Phone: 0300 123 6780
Email: lhscustomerservice@lancashire.gov.uk
Your ref:
Our ref: LHS/CS/3/2016/0493
Date: 22nd June 2016

Proposal:	Discharge of condition(s) 3 (removal of render), 4 (pointing), 5 (new entrance gate), 6 (roof slate) and 7 (windows and doors) of planning permission 3/2016/0201 and 0202
Location:	Southport House Sawley Road Sawley BB7 4LE
Grid Ref:	377629 - 446187

5011-JK3
PROPOSED GATE DRAWING
1:100 @ A3
SPA ARCHITECTS
MAY 16

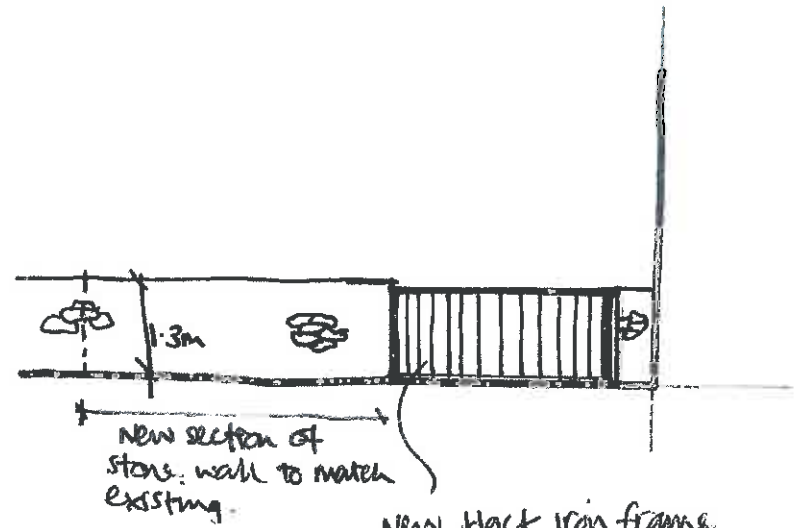
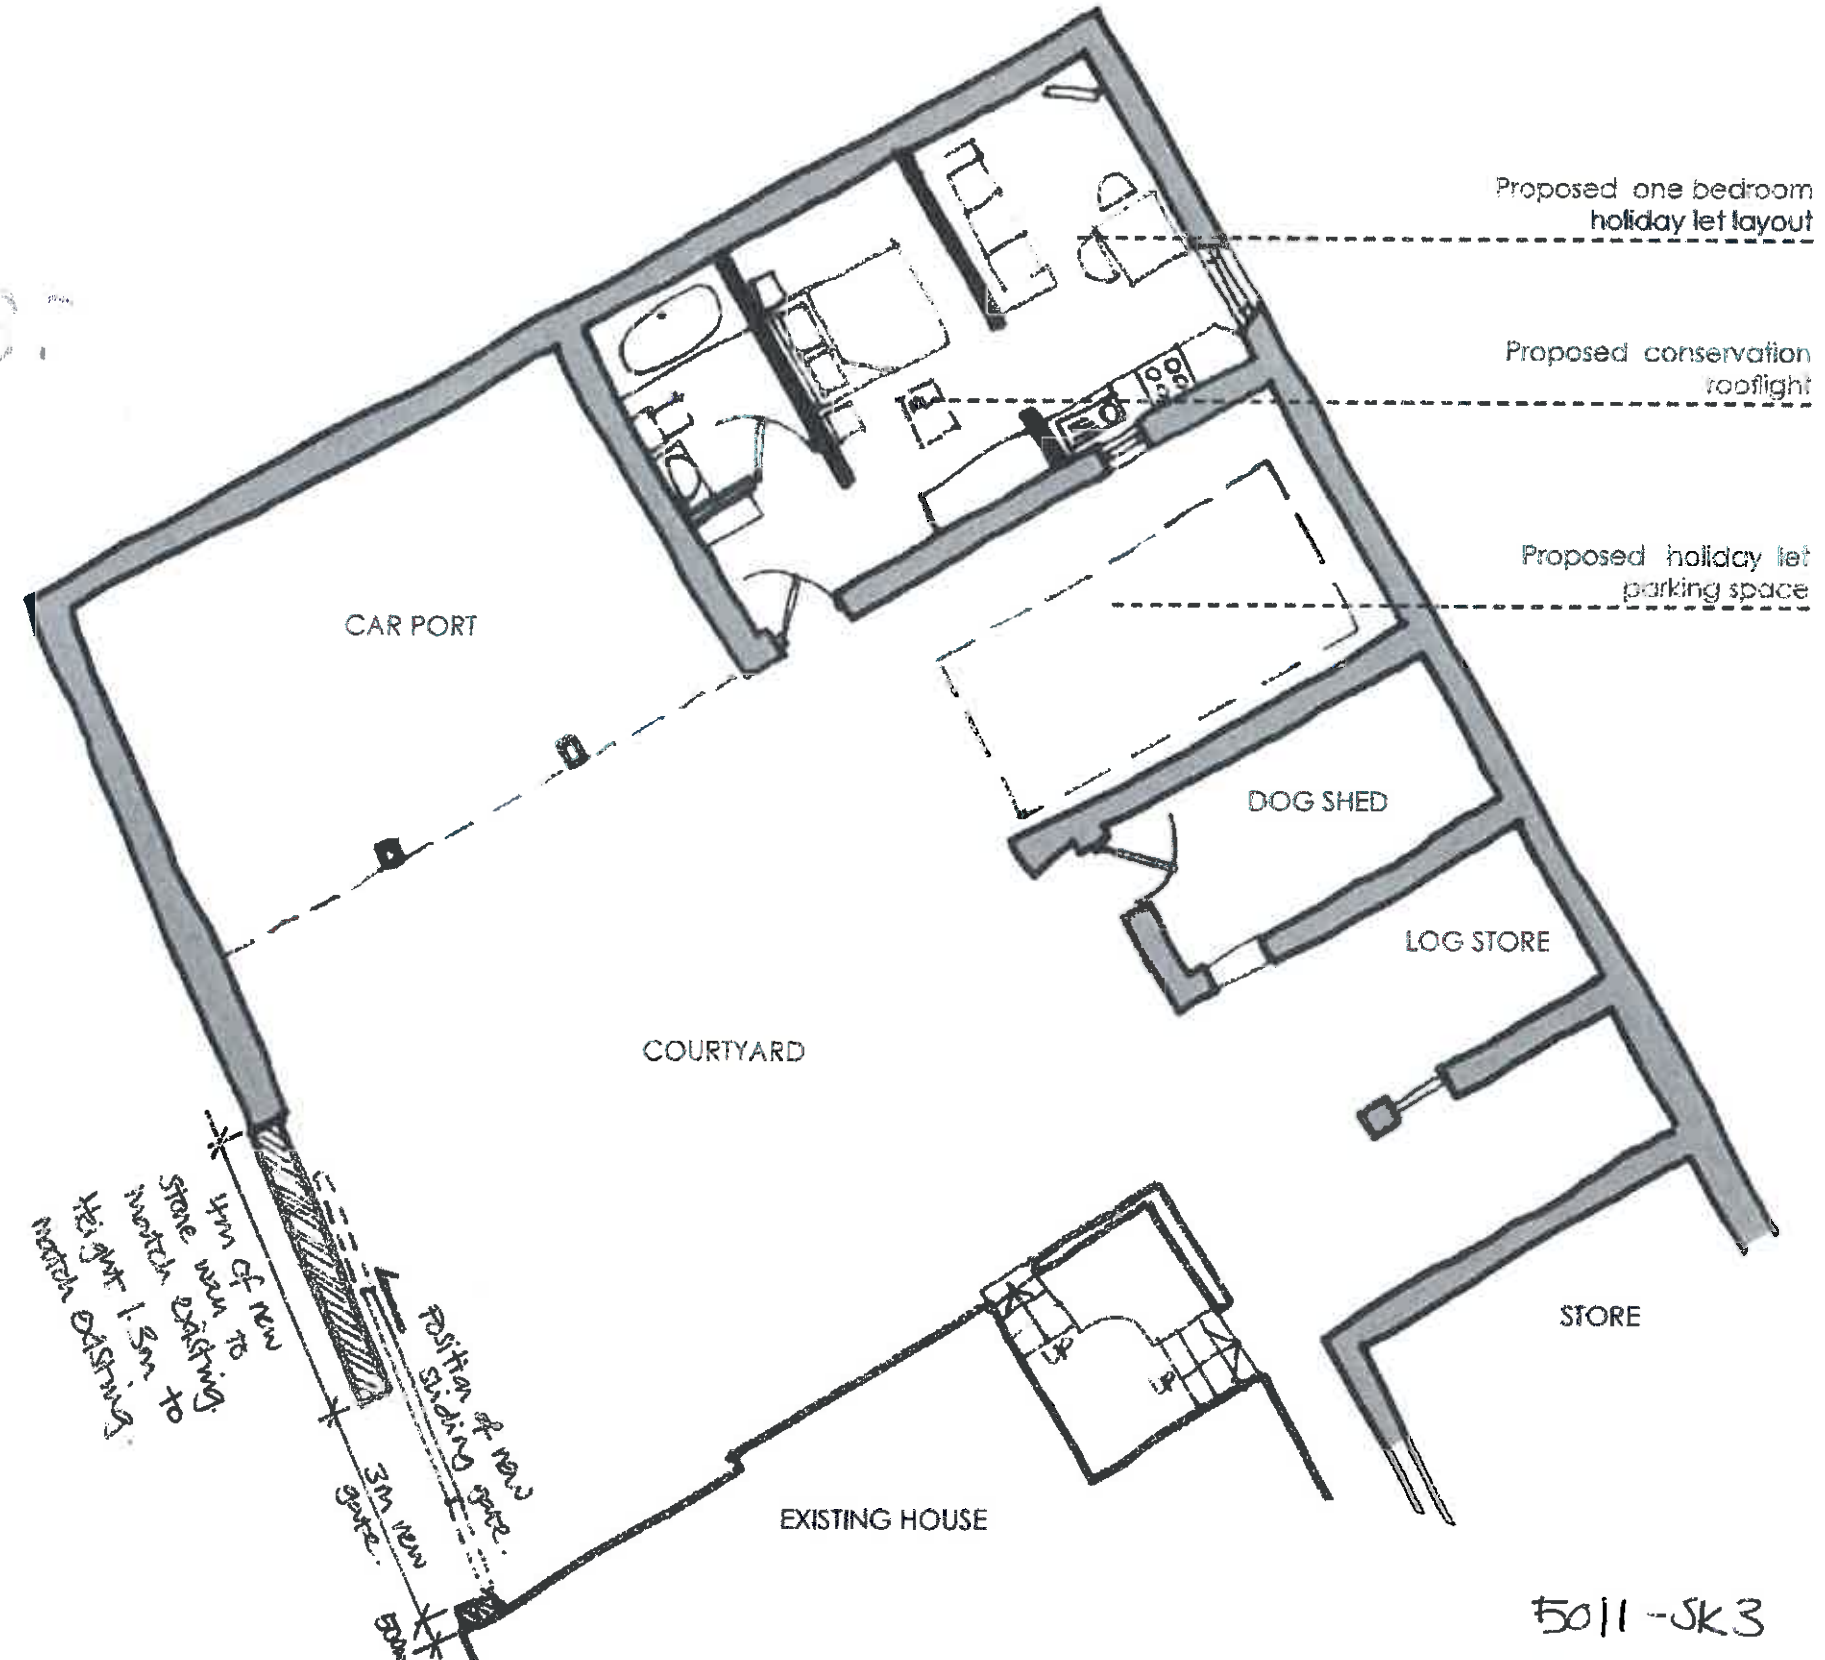
The shown gate details are acceptable providing the gate and new section of wall have a maximum height of 1m to ensure the sight lines are not obstructed.
